Our Ref: ABP-301908-18

Re: Greater Dublin Drainage Project consisting of a new wastewater treatment plant, sludge hub centre, orbital sewer, outfall pipeline and regional biosolids storage facility  
Townlands of Clonshagh, Dubber and Newtown, County Fingal and Dublin City

Description of the Development: Micro tunnelling at R122 at Baleskin Centre where 2 x planning notices for this development is located. Odour Control Unit installation.

**Location: Near Baleskin Centre – R122, St Margaret's Road.**

Drawing Title:
ODOUR CONTROL UNIT PLAN AND ELEVATION

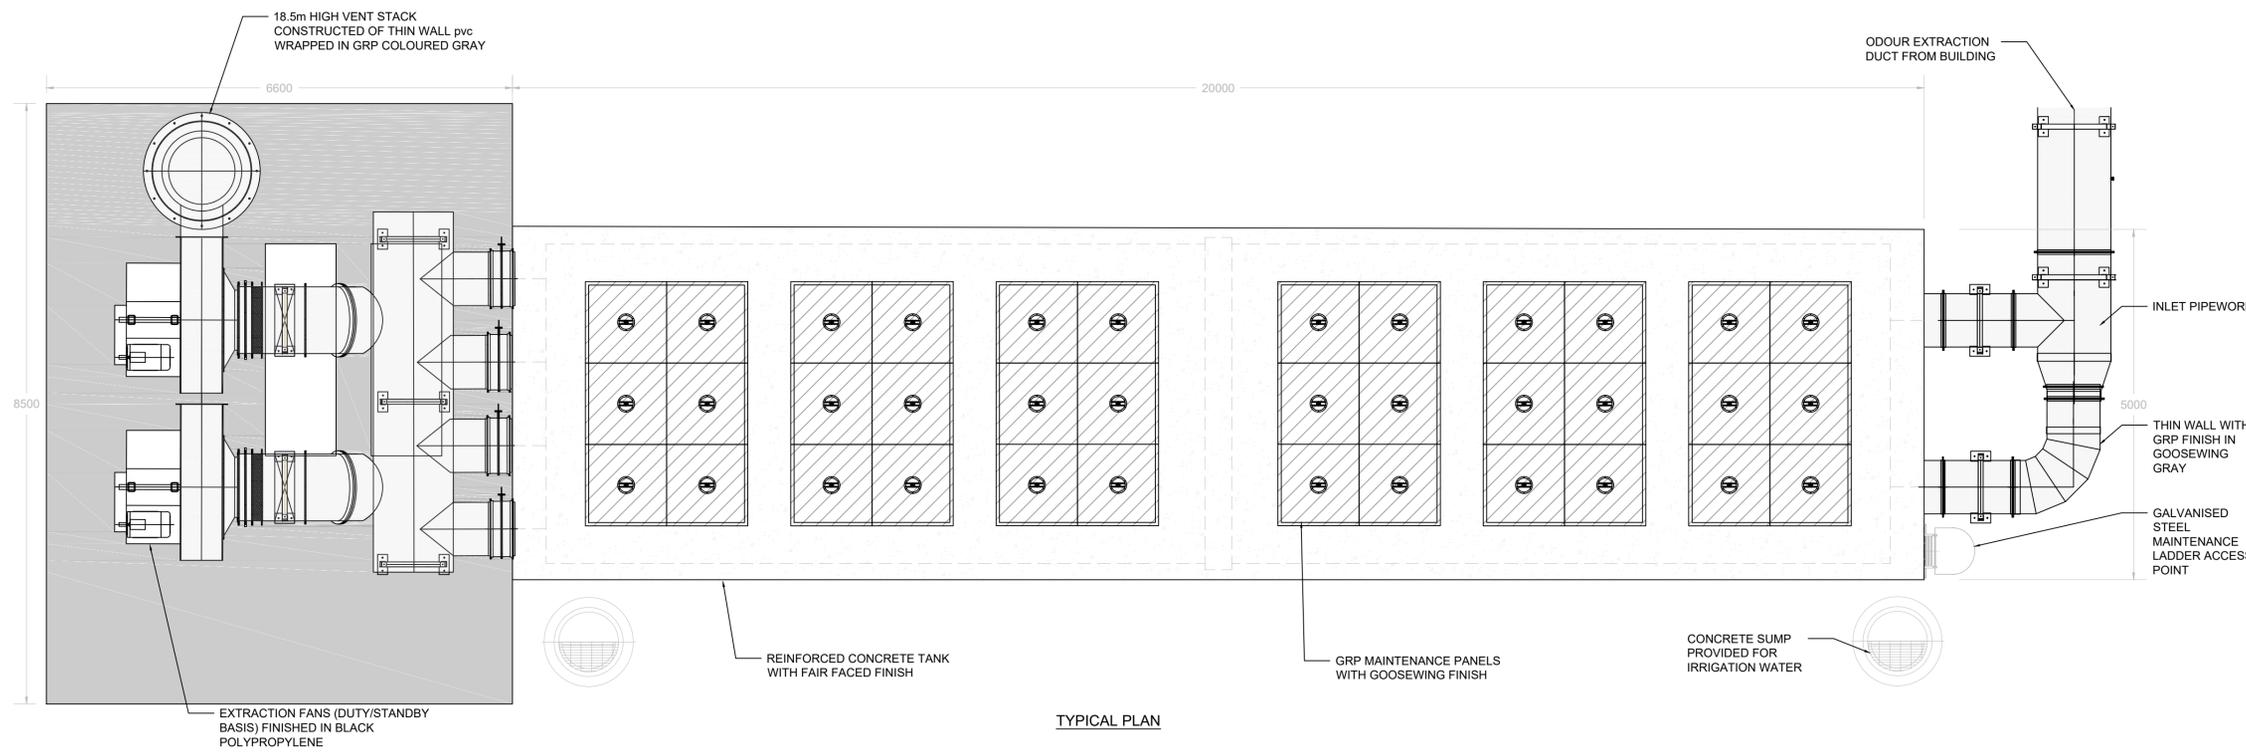
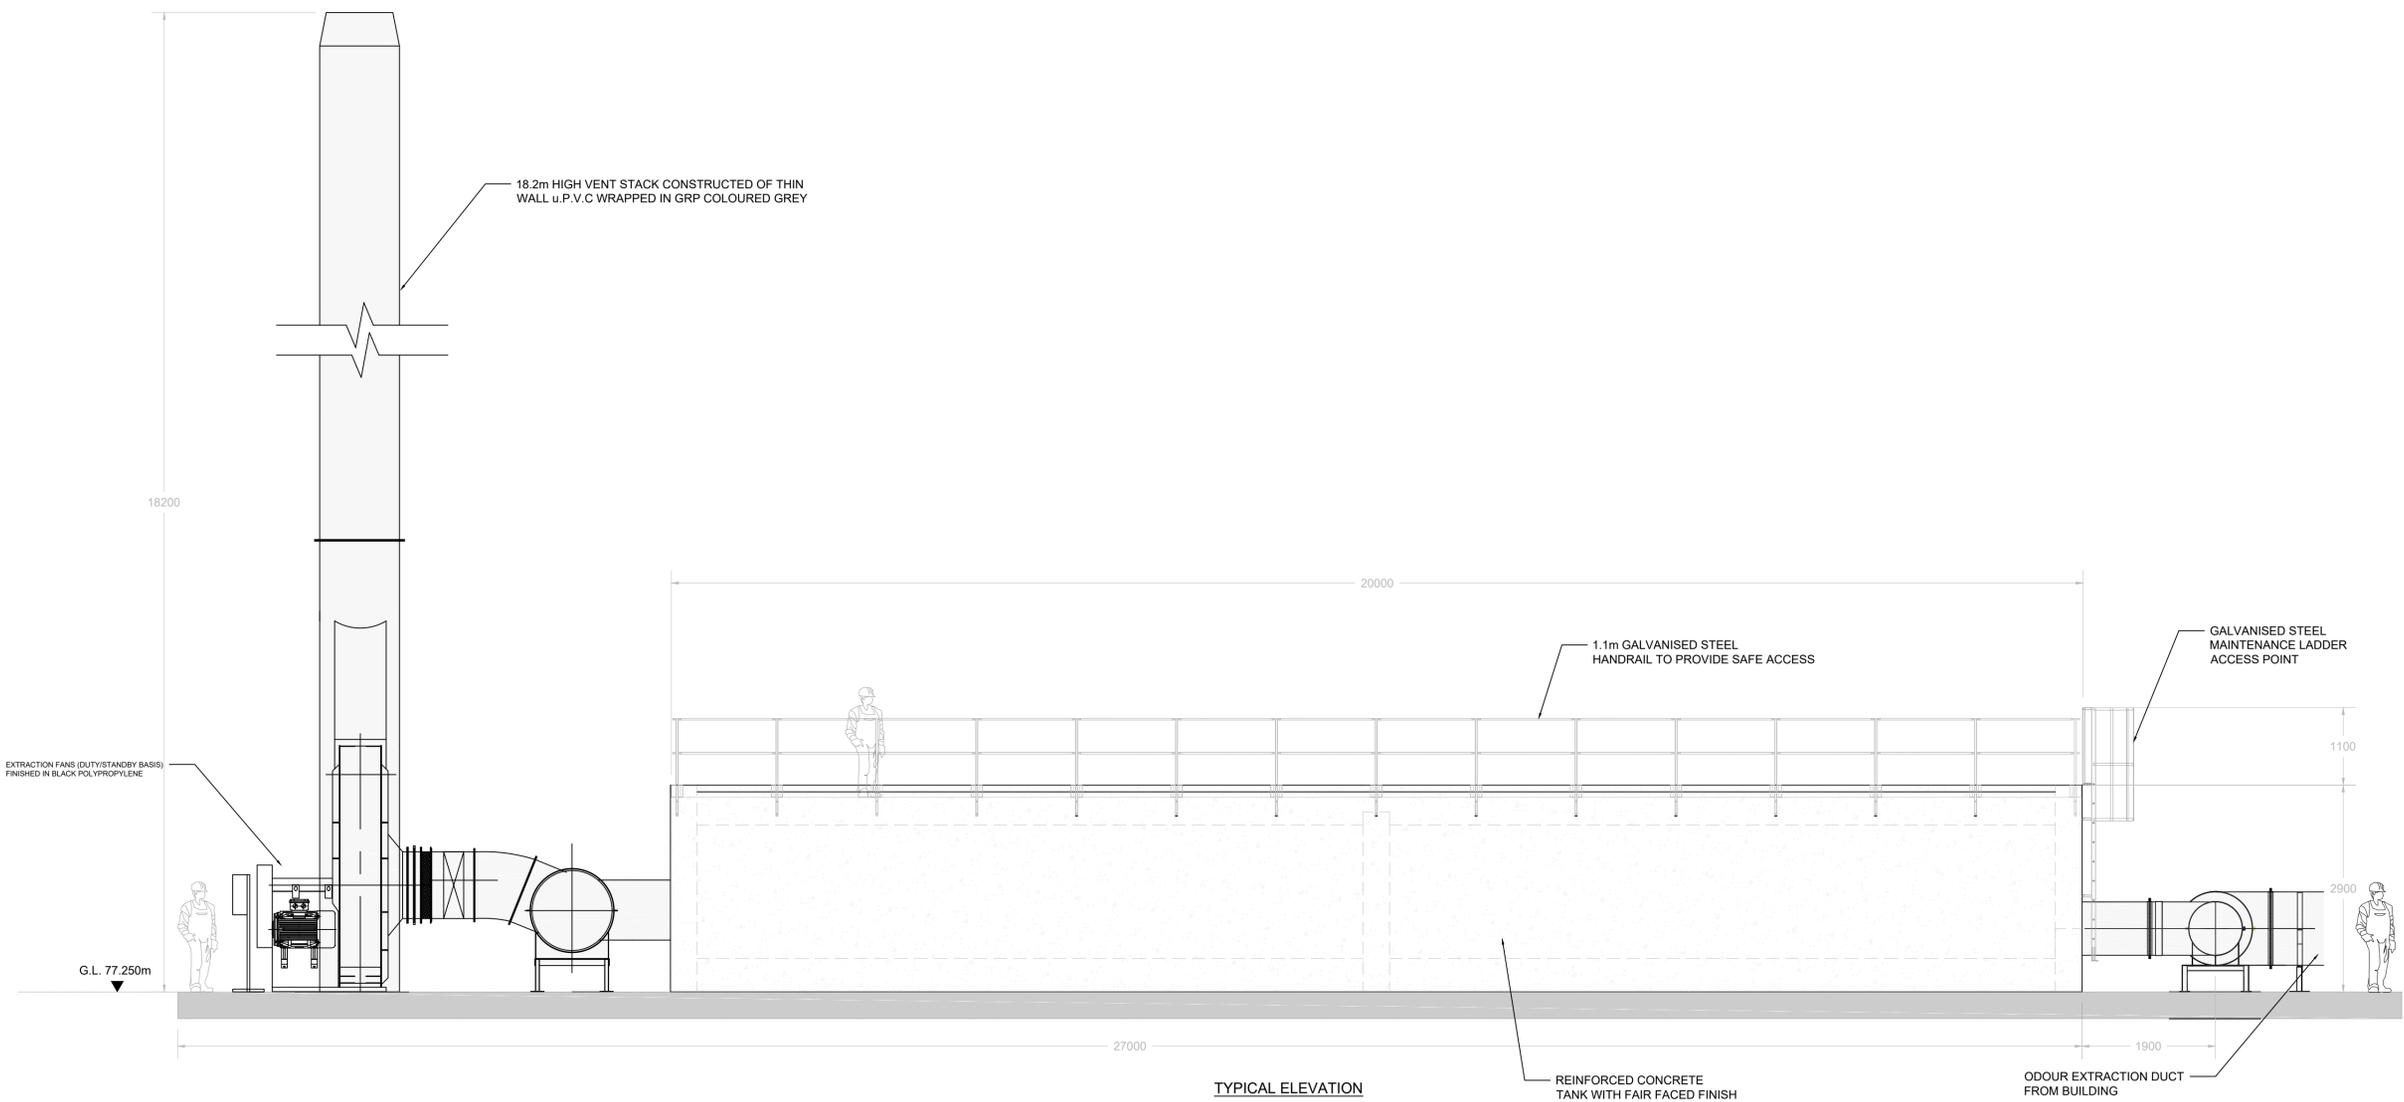
2) There is no need for this plant as the odour can be controlled chemically at the pumping station and we urge that this odour control unit is not placed at Meakstown.

3) There is no information as to who will be maintaining the plant if anyone, no information as to what material will be used and no information as to when this material will be changed.

4) We viewed an odour control unit located at Julianstown and there is noise coming from this unit. This will add to the existing M50 and Dublin Airport noise pollution we already experience. The building located at Julianstown is an unsightly building and development and adds no value (and in fact reduces the value) to our already over developed (with zero community facilities) to Meakstown.

We have odour concerns with these proposed **'odour control units'**. From research we understand these buildings will be 5 metres high.

Why are they only 5 metres high? As per our research they are normally up to 25metres high and above. Has Irish Water engaged with Dublin Airport Authority on this project as with gases and from a business continuity perspective they need to be aware of this proposed planning which we do not want located in Meakstown?.
